Emailed January 3, 2020
DRB Comments for Meeting on 1/8/2020

RE: DRB COMMENTS for PR-2019-002333

Lots 10A, 11A, 11B, and 12A, UNIT 1 PARADISE HILLS (Viva Paradise Town Homes): B-11

SI-2019-00420 – Site
Plan

TITLE: VIVA PARADISE TOWN HOMES
CONCEPTUAL GRADING AND DRAINAGE PLAN

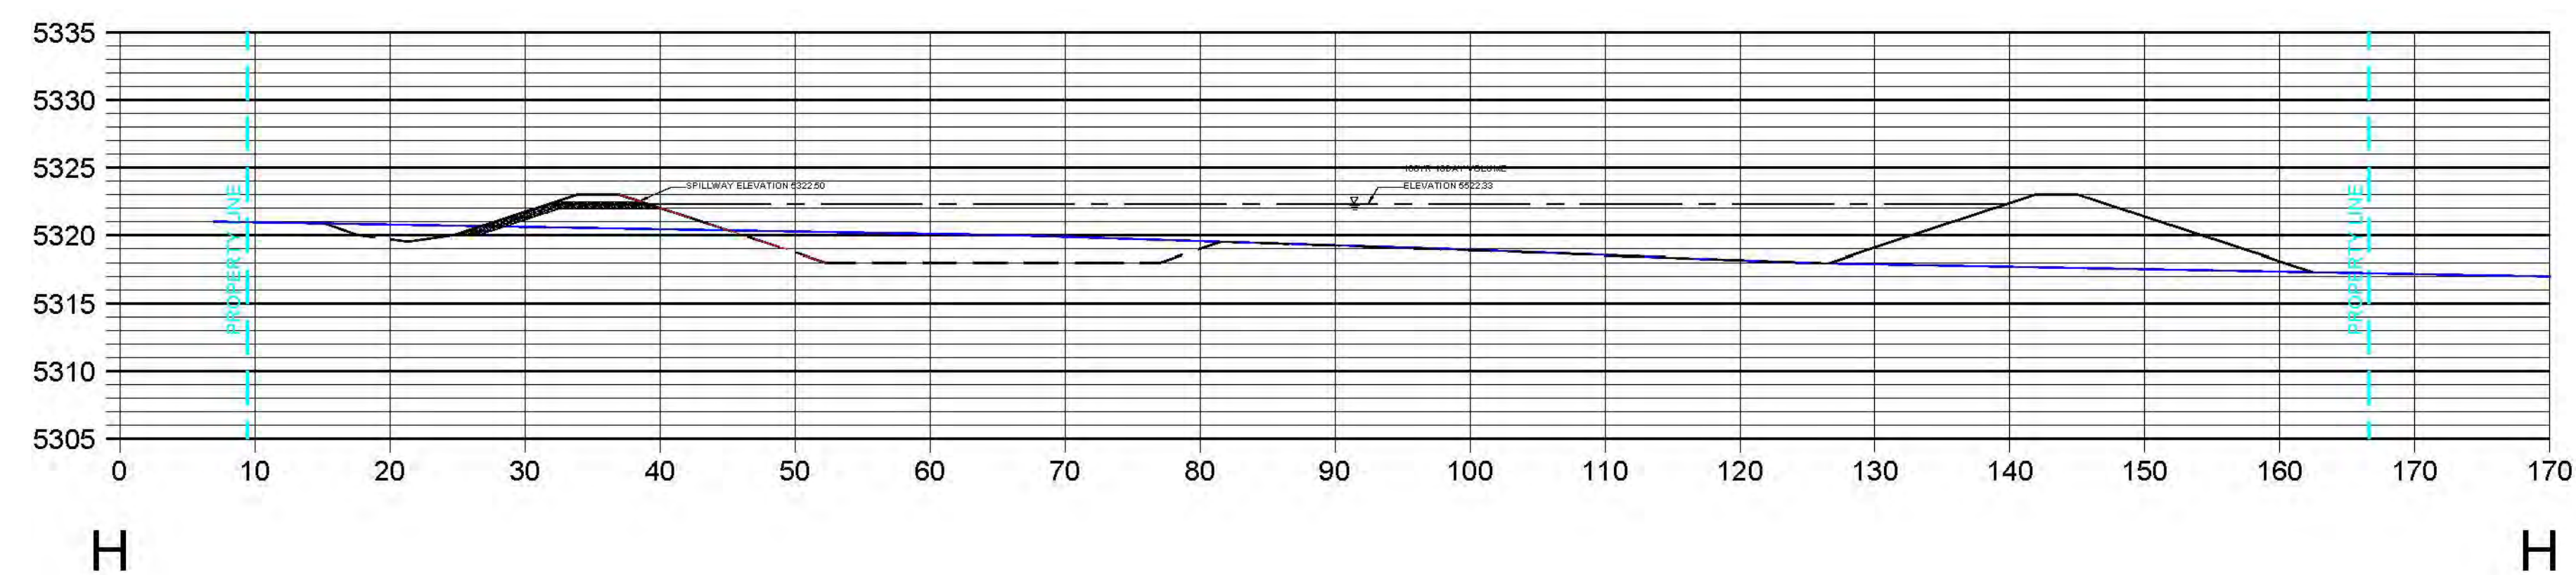
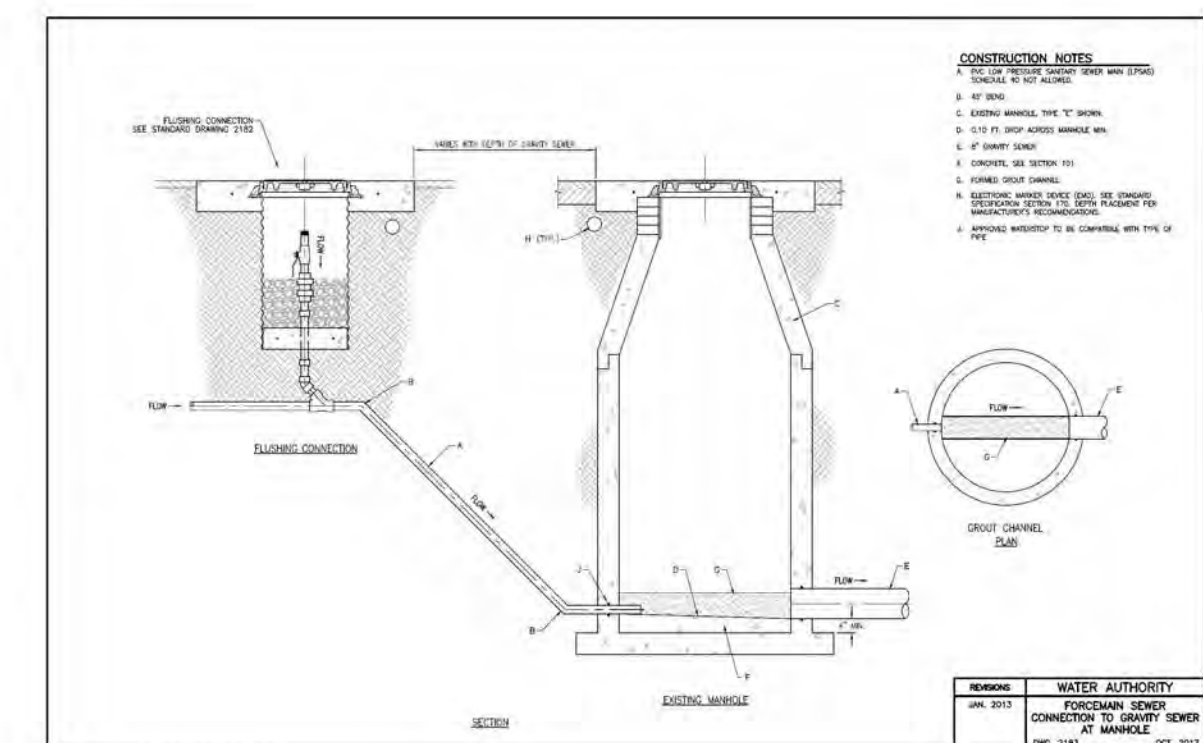
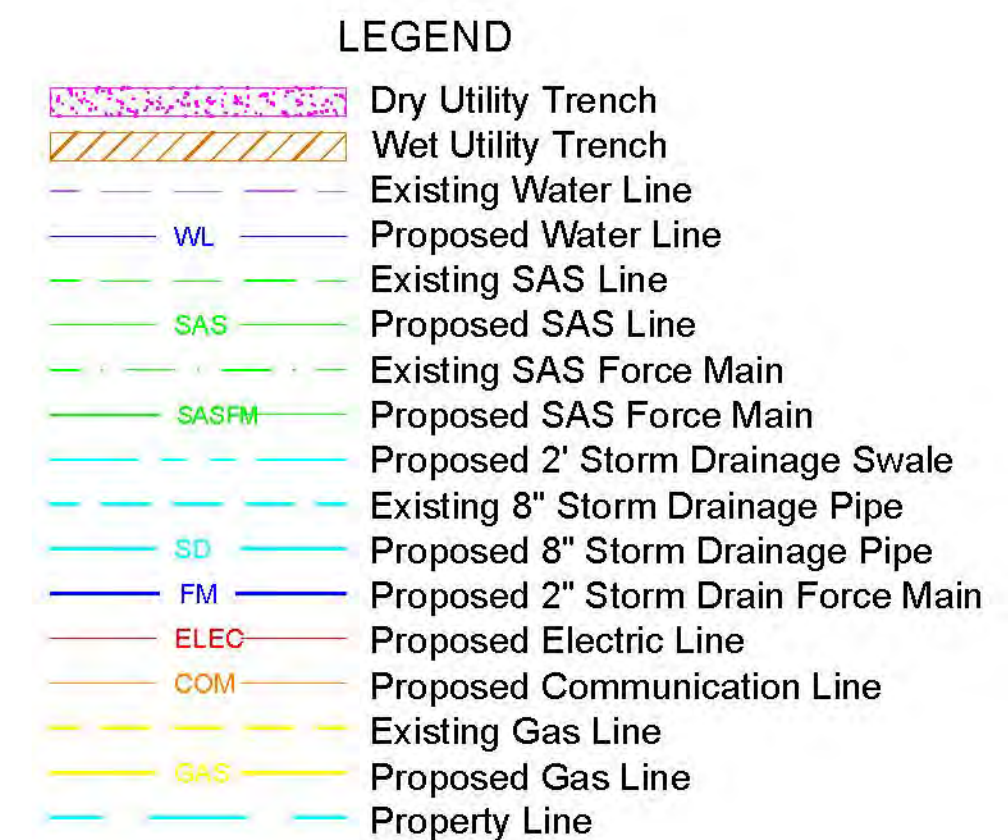
- Identify what downstream infrastructure is being referenced on the G&D Plan.
- AMAFCA has no planned facilities in the area, therefore City Hydrology should verify this is in conformance with the master plan.
